Mallard Pass Solar Farm

Environmental Statement Volume 2 Appendix 6.3: Landscape and Visual - Consultation Summary

PINS Ref: EN010127

Appendix 6.3 - Consultation Record and Responses Relevant to ES Chapter 6: Landscape and Visual

DRAWING TITLE
Figure 6.11: Green Infrastructure Strategy Plan

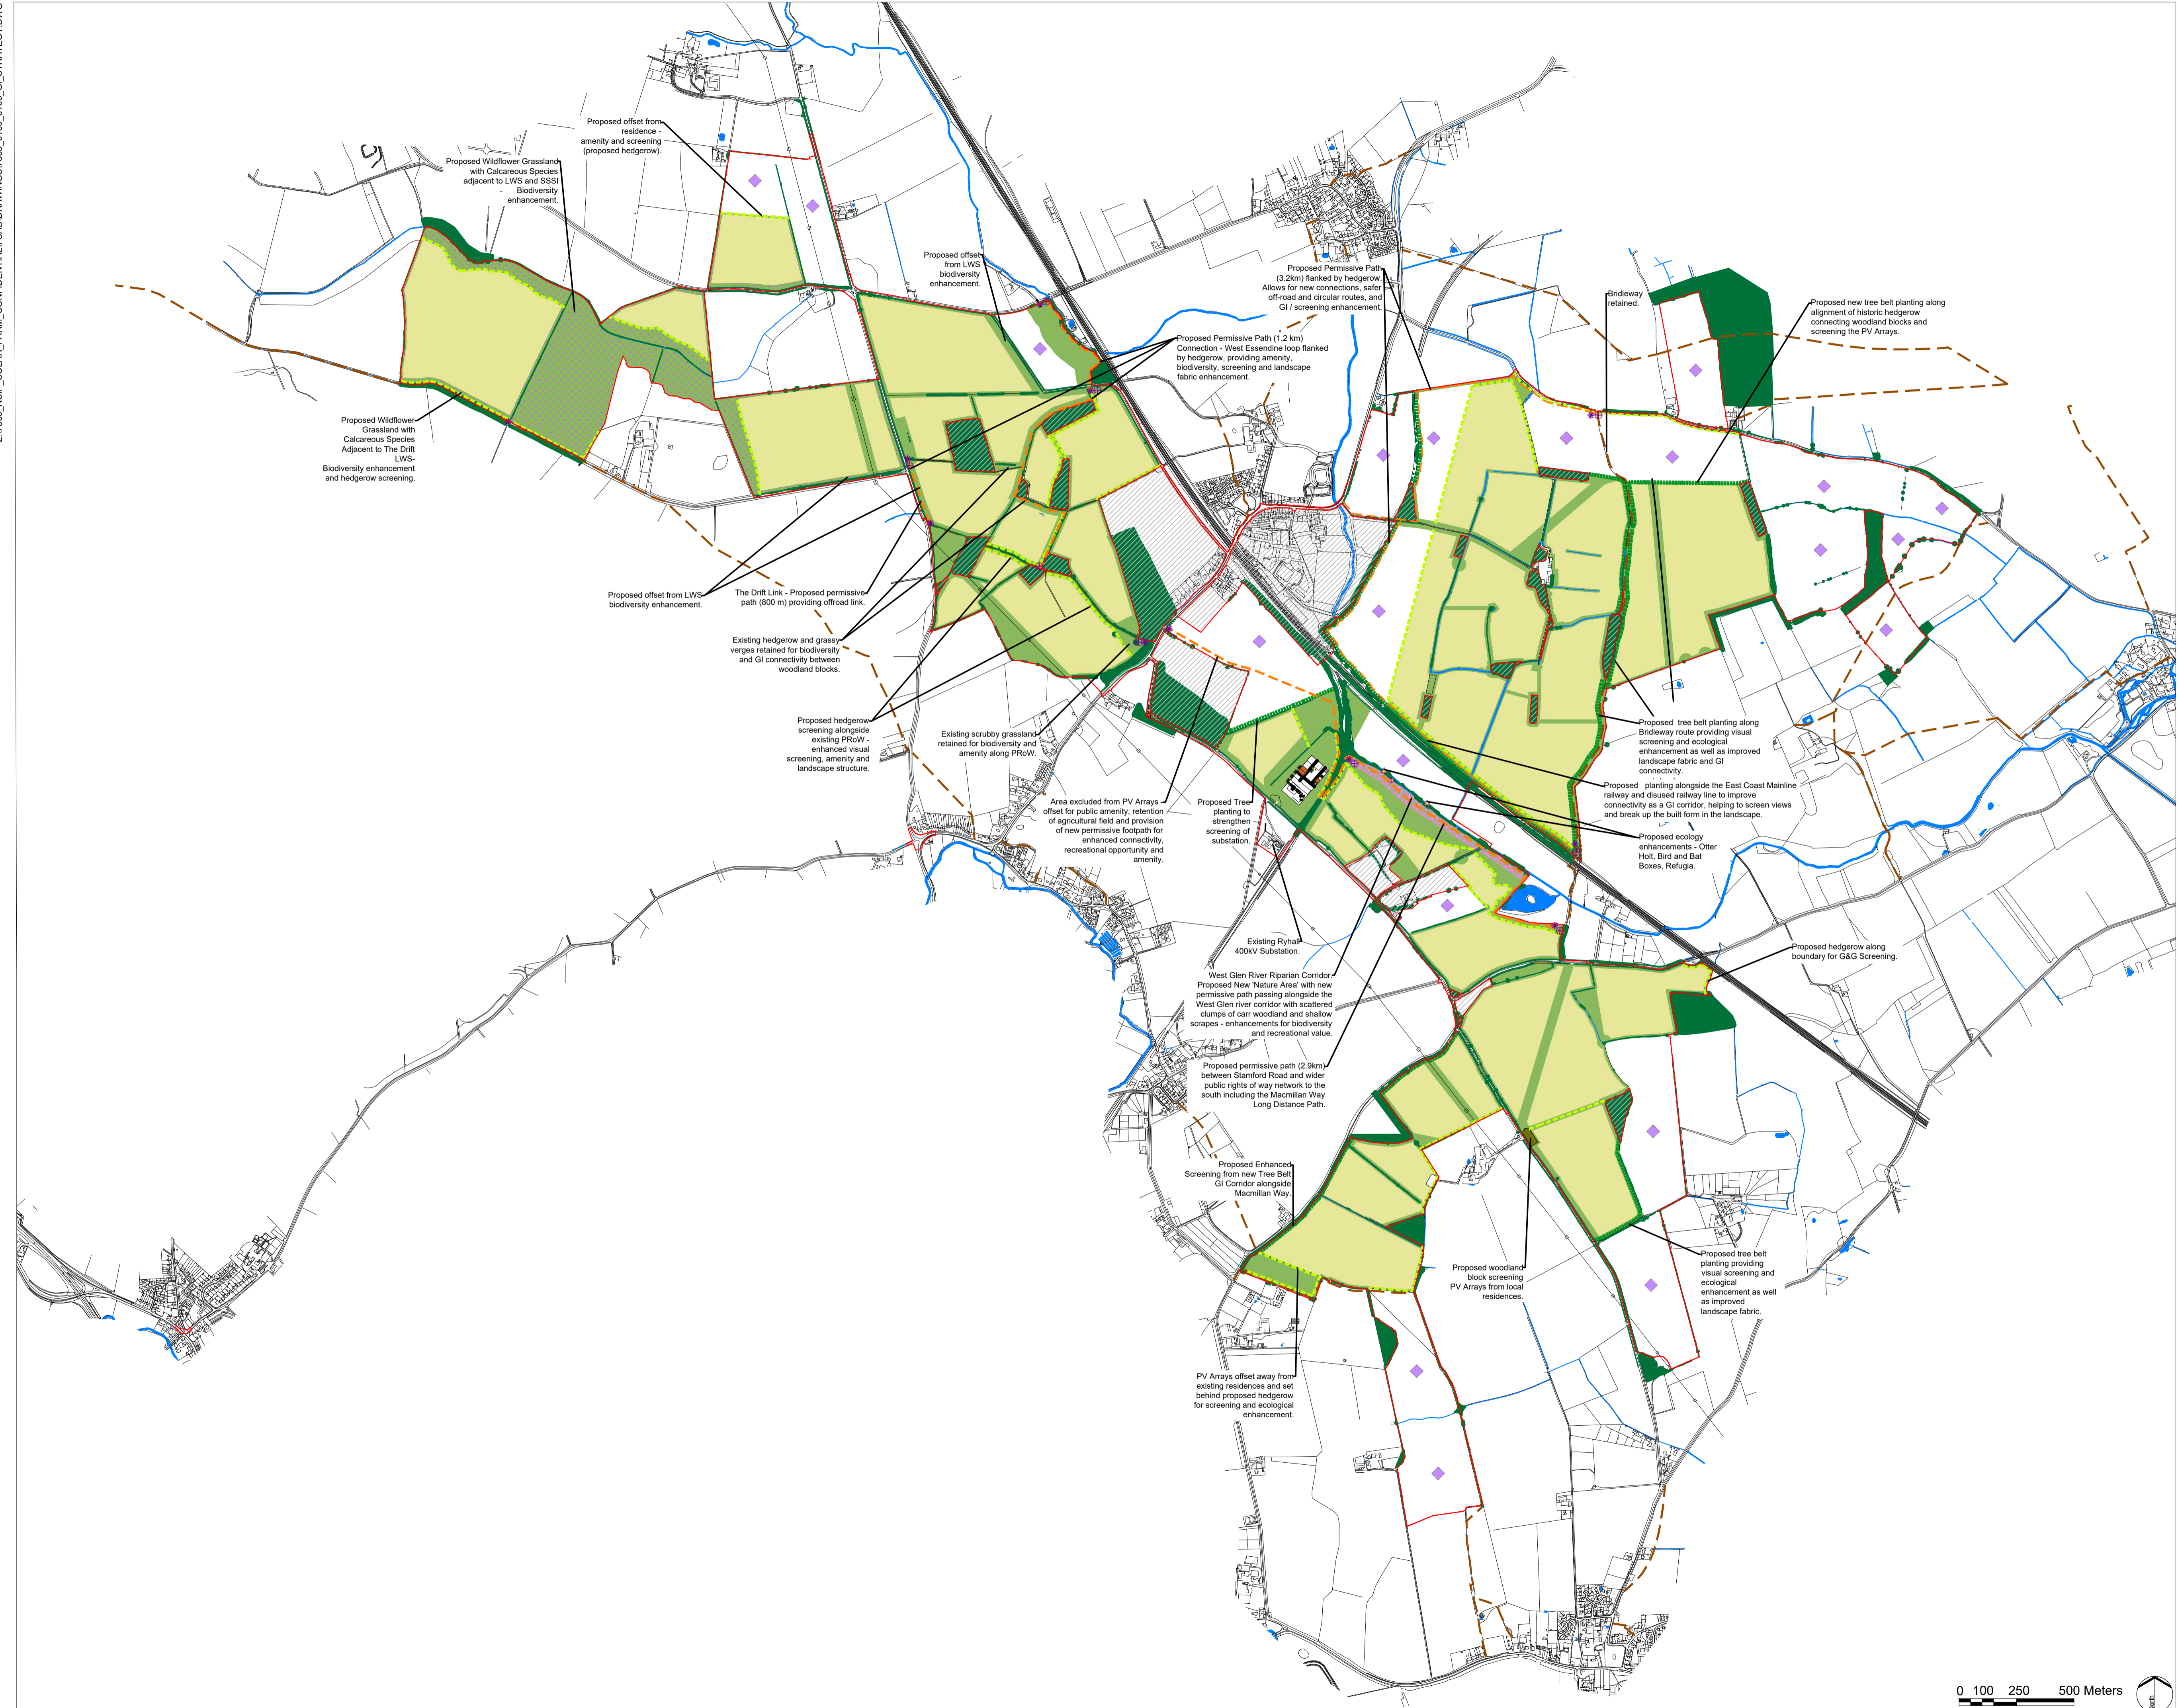
LCC	5 th October 2022	Planting specifications requested for areas shown on the proposed Green Infrastructure Plan (Figure 6.11).	Outline planting specifications have been provided within the oLEMP.	oLEMP
LCC	5 th October 2022	Visualisations - further detail to be provided on the Onsite Substation.	The rendered visualisation at representative viewpoint 11 has been updated to provide further details of the Onsite Substation.	ES Chapter 6, LVIA - Figures 6.10.A – 6.10.E.

DRAWING TITLE
Figure 6.6: Zone of Theoretical Visibility (ZTV) Study, Representative Viewpoints and Illustrative Viewpoints

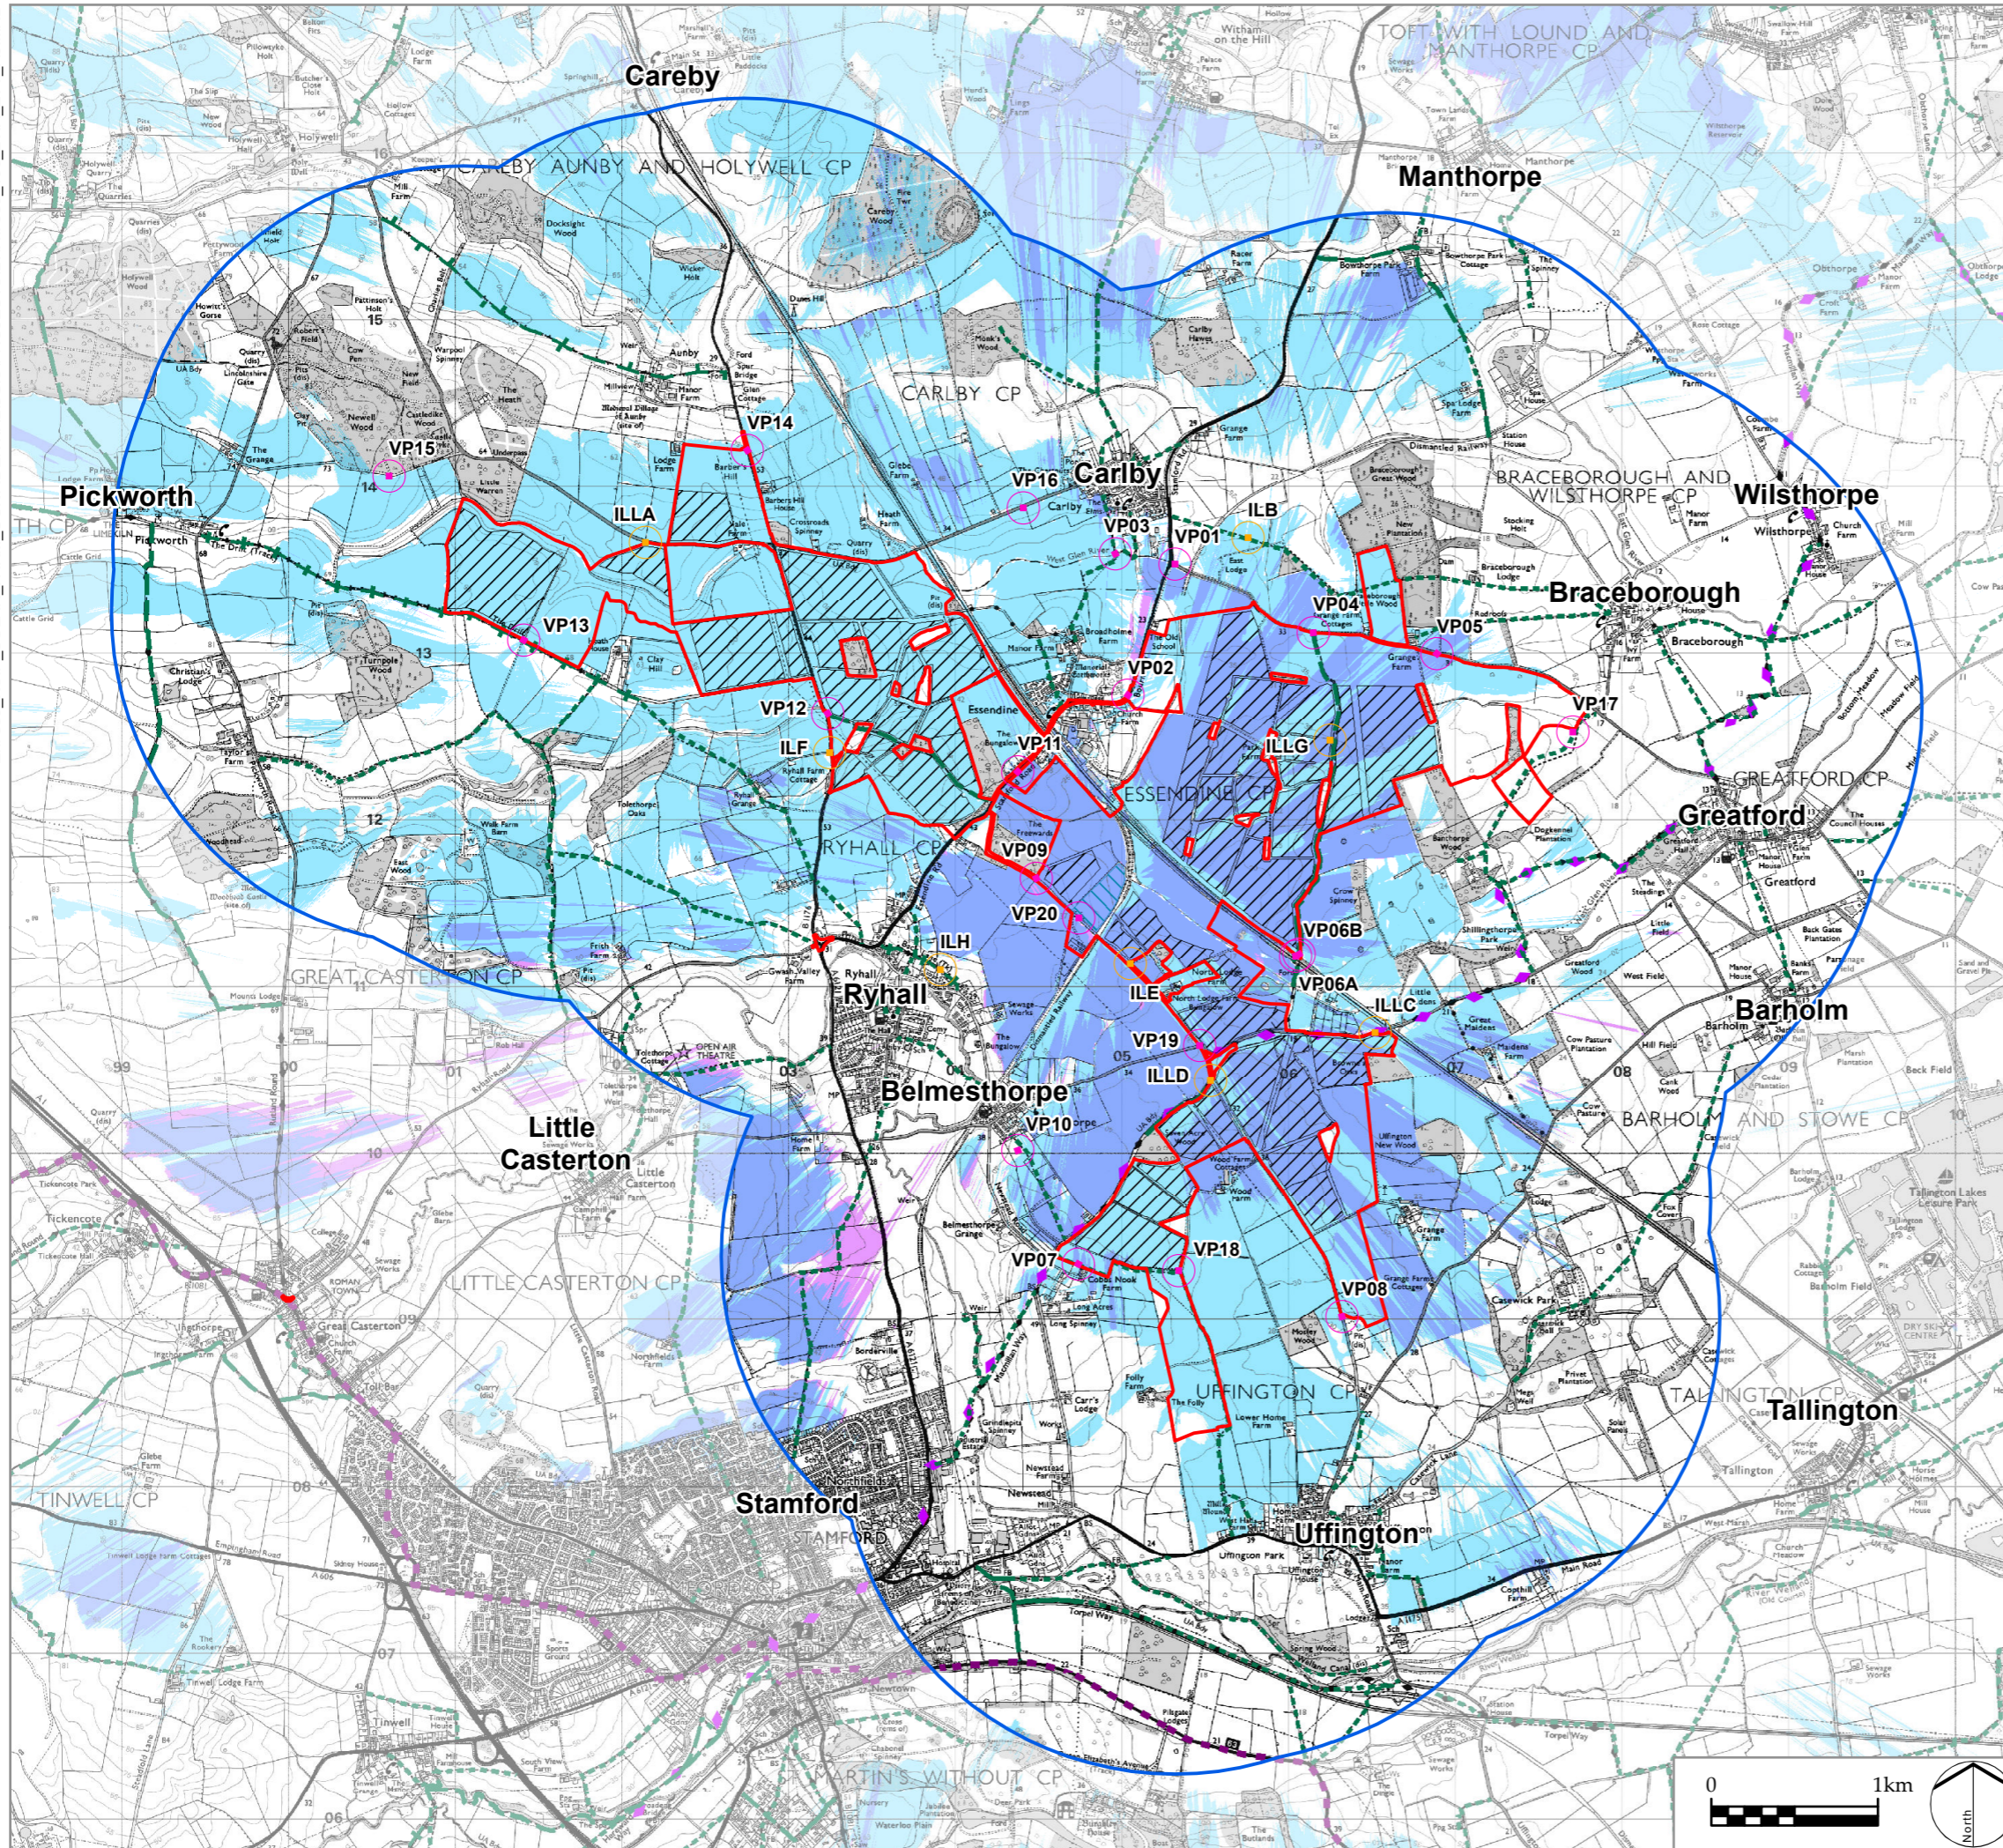
Consultee	Date of Consultation	Main Matter Raised	How has this Matter been Addressed	Where is the Matter Addressed in the ES
			Lincolnshire Historic Landscape Characterisation Project.	
LCC	3 rd August 2022	Development parameters regarding the detailed heights of the main solar PV components including the substation and ancillary buildings requires further clarification as a development parameter.	<p>The development parameters are clearly set out within the ES Chapter 5, Project Description, Appendix 5.1 and – Works Plans.</p> <p>The applicant has sought to reduce the overall heights of the key components as far as possible within the technical constraints of the solar PV development.</p>	ES Chapter 5, Project Description, Appendix 5.1
LCC	3 rd August 2022	ZTV to be updated to reflect the updated development parameters and for the taller solar PV components.	The ZTV's have been updated to show the extent of potential visibility for the solar arrays at 3.3m height or the maximum height parameter for the Fixed South Facing (FSF) or Single Axis Tracker (SAT) panels. A ZTV has also been generated at 13m height to consider the maximum height parameter for the Onsite Substation within the Order limits.	ES Chapter 6, LVIA - Figure 6.6

LCC	3 rd August 2022	Further justification to be provided for the extent of the 2km study area within the LVIA as the ZTV indicates that visibility extends	The ZTV mapping indicates areas of potential visibility based upon digital ground model and topographic data. The ZTV combined with fieldwork has shown that the likely significant	ES Chapter 6, LVIA - Section 6.2, Figure 6.6
